Our ref: 100148-PEF-ZZ-XX-RP-YE-000400
Planning Ref: BN/11/22/OUT
EA Ref: HA/2022/123981/01-L01

Arun District Council
Development Control

BARNHAM EASTERGATE WESTERGATE – RESPONSE TO ENVIRONMENT AGENCY’S HOLDING OBJECTION IN RELATION TO FLOOD RISK ISSUES

Drawing Title
**INITIAL BRIDGE OPTIONS
MULTI SPAN**

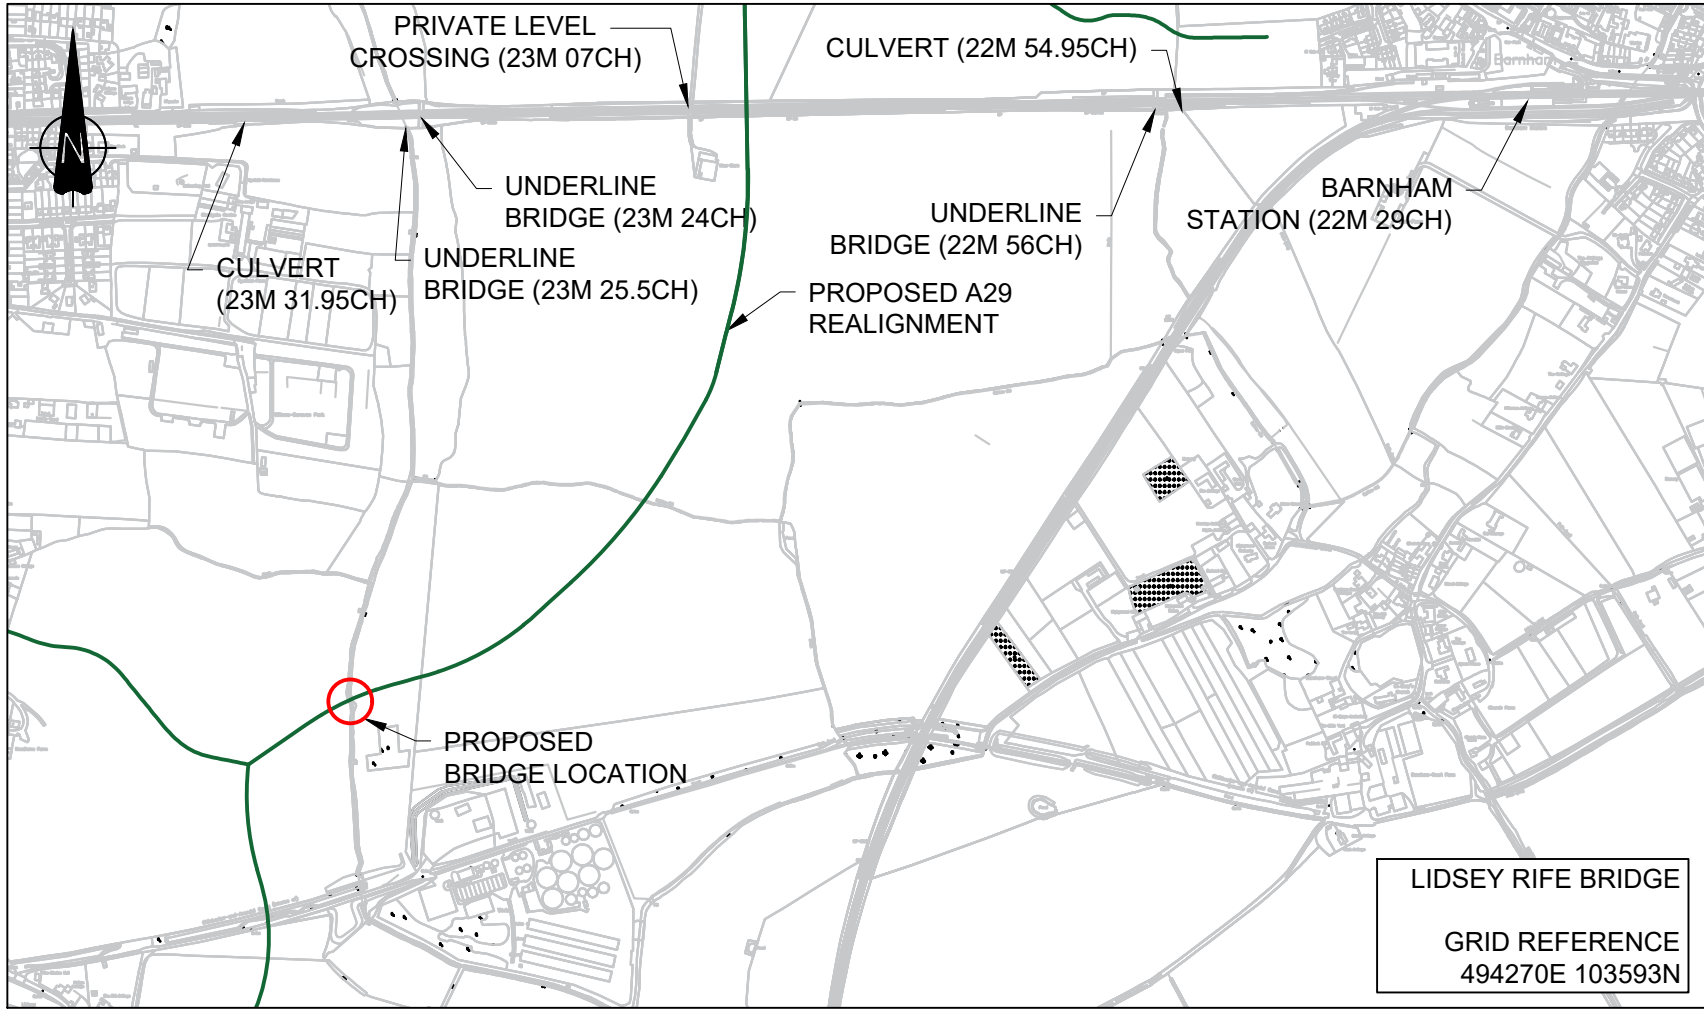
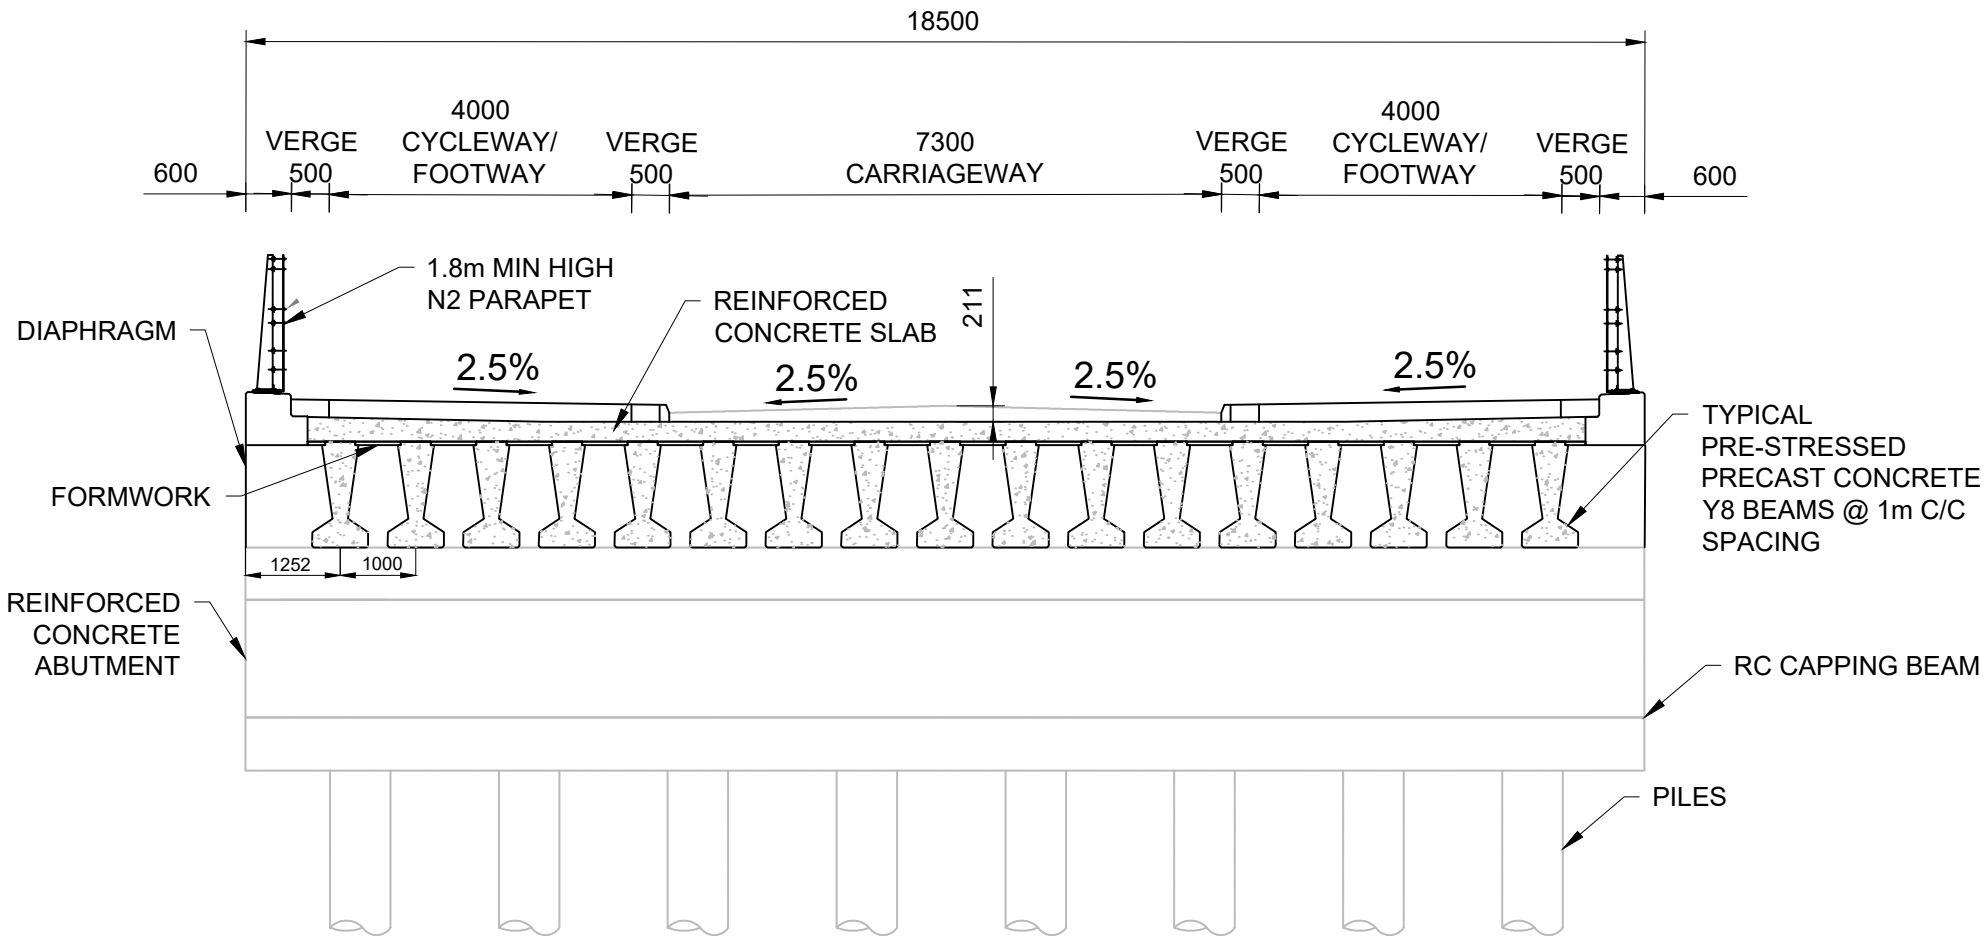
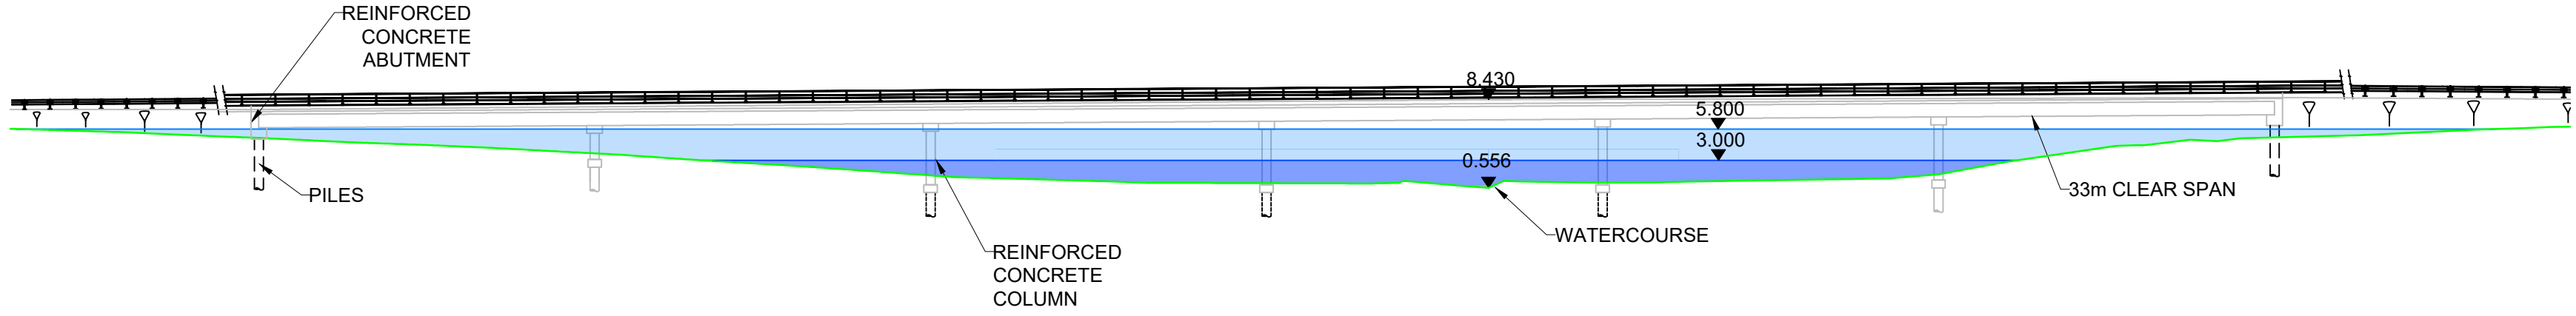
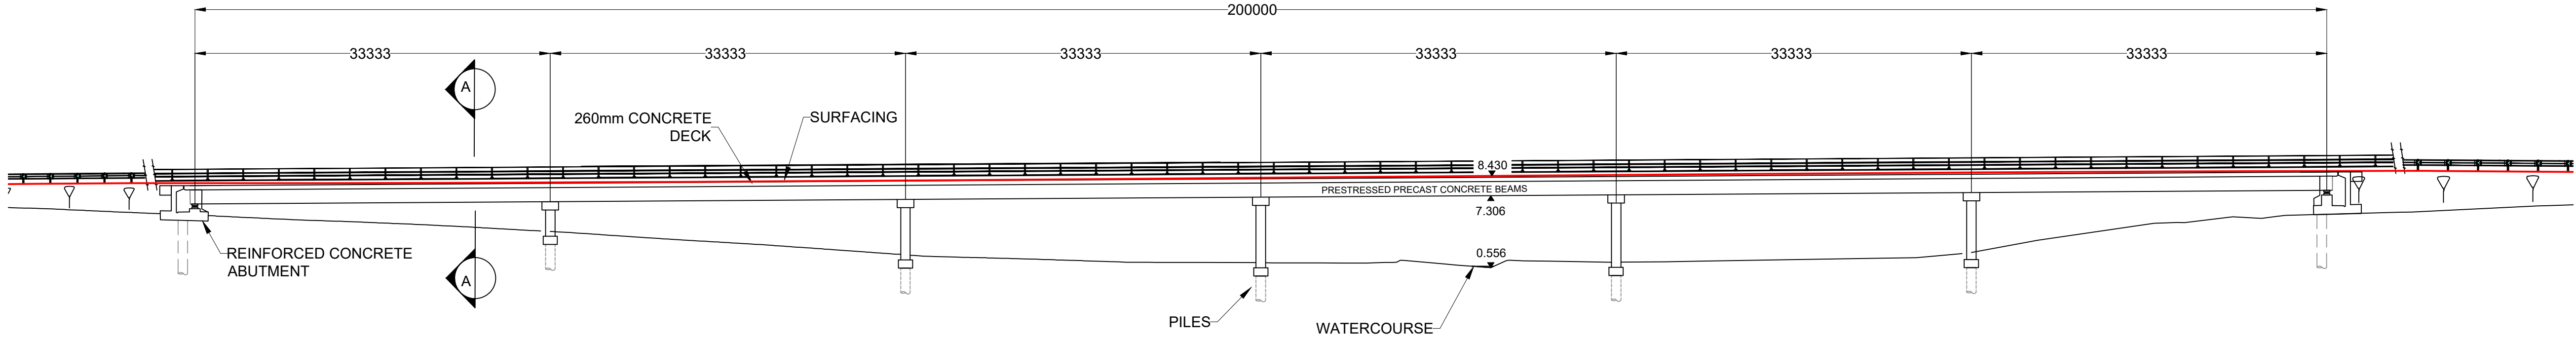
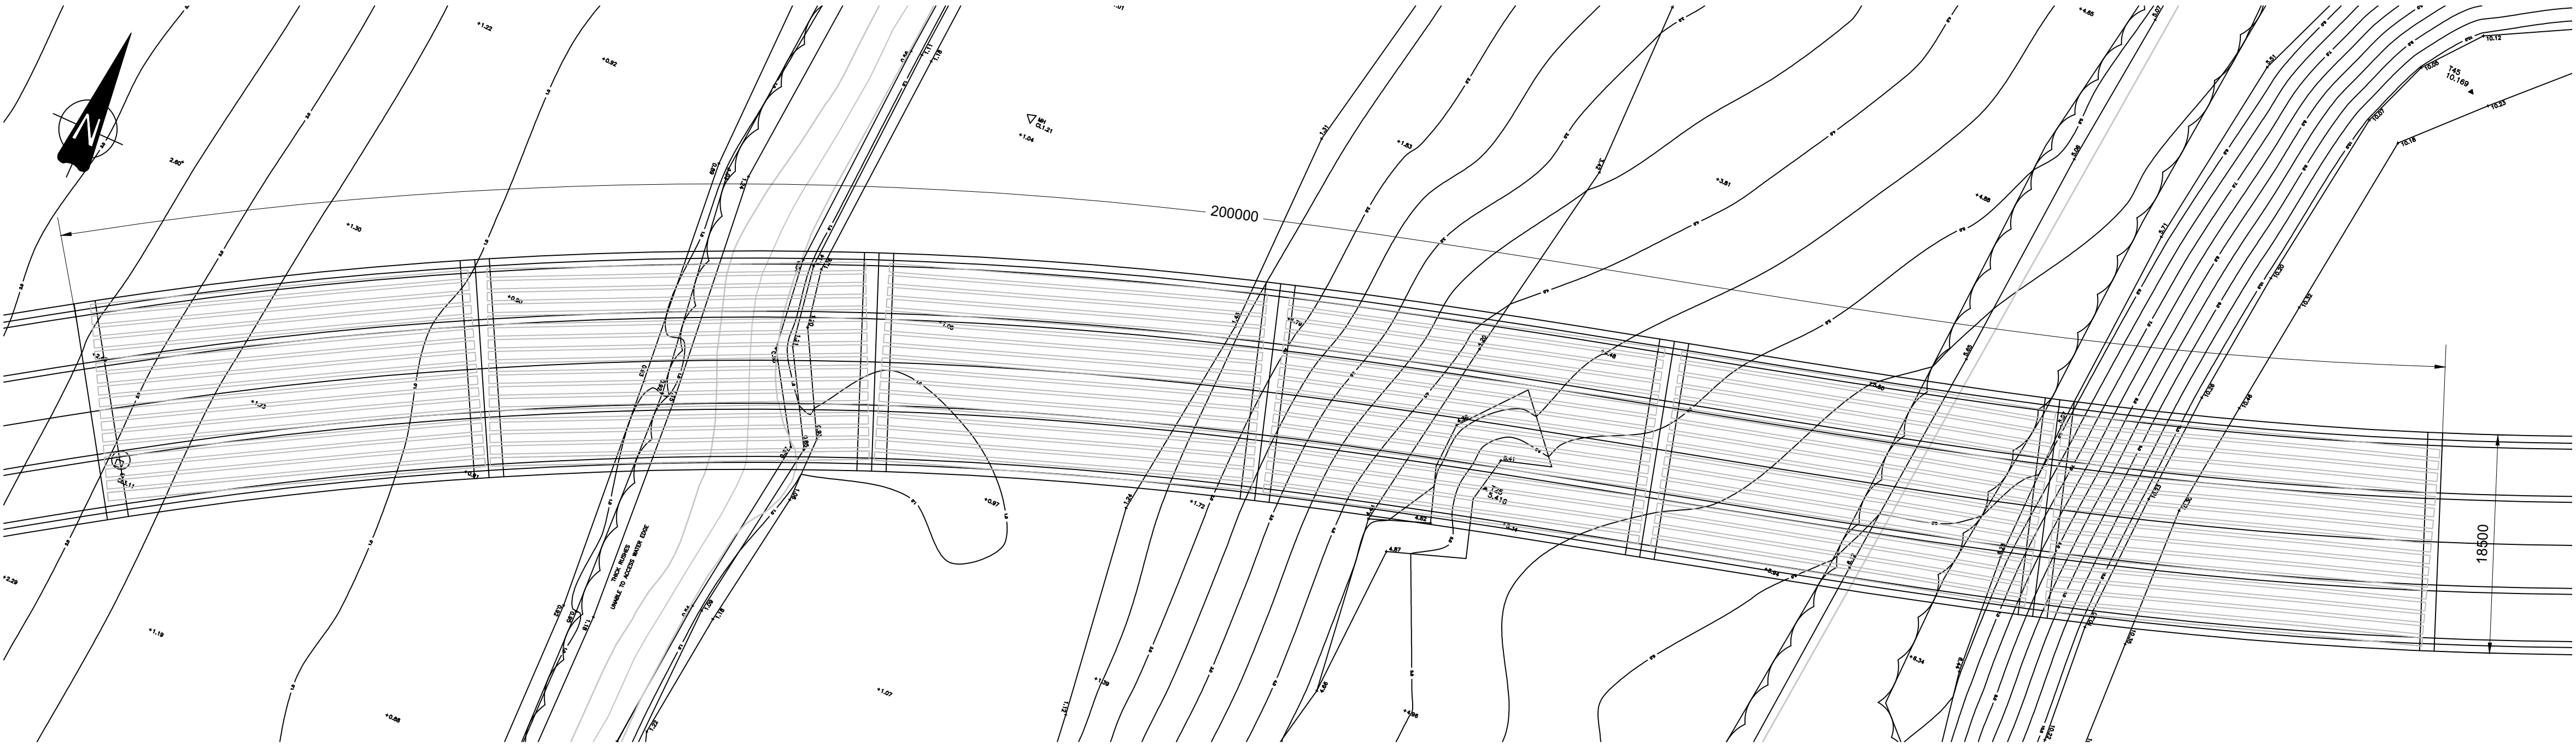
4.1.3. An option for a multi-span bridge to bridge the entire floodplain and defined valley of the Lidsey Rife was considered and discounted, because:

- Approximately 7 piers, plus abutments at either end of the bridge would be required and would not be perpendicular to the predominant flow direction, which can disrupt flows and increase the risk of blockage. The road alignment cannot be amended due to the design speeds of the road that requires minimum radii for curves, coupled with the constraints on the alignment as it passes over the Lidsey Rife, then heads south over the access to the treatment works and other facilities.

- Maintenance constraints in terms of accessibility for inspections and the introduction of increased points of vulnerability and degradation at expansion joints between the bridge sections.

- It increases the intrusive piling and foundation works needed to construct the additional piers, which in an area with known elevated groundwater could cause additional works in terms of dewatering of excavations and/or introduce potential pathways for surface contaminants and pollutants to enter groundwater receptors.

Overall, due to the introduction of a number of additional locations vulnerable to degradation, increased difficulty in inspection, heightened vulnerability to structural damage and anticipated cost of the structure, means this design was discounted as an unviable option.

Nevertheless, hydraulic modelling has been carried out of the design event to understand the flood risk implications of such a structure. When including the location and number of piers recommended as part of the Bridge Options report this results in a change to the 2D mesh within the hydraulic model that means direct comparison of the 2D results is inappropriate. A drawing has been prepared (A1994-PEF-ZZ-XX-SK-YE-0805) that shows spurious changes to peak water levels throughout the domain that are unlikely to be caused as a result of the bridge piers. However, comparing the in-channel levels as before shows a nominal increase in water level upstream of the structure of 0.005m (5mm) and similar changes in the order of +/-4mm downstream of the site to the embankment option.

Whilst the multi-span option with piers results in smaller changes to the peak flood depths, it is not considered a substantial enough betterment to the existing flood situation to warrant its preference over the embankment option due to the associated disadvantages of the design approach. With the piers set skewed to the preferential flow direction, the possibility of blockage and structural damage is increased and does not warrant progression of a solution that would be more susceptible to damage, and potentially be unviable from a cost perspective.
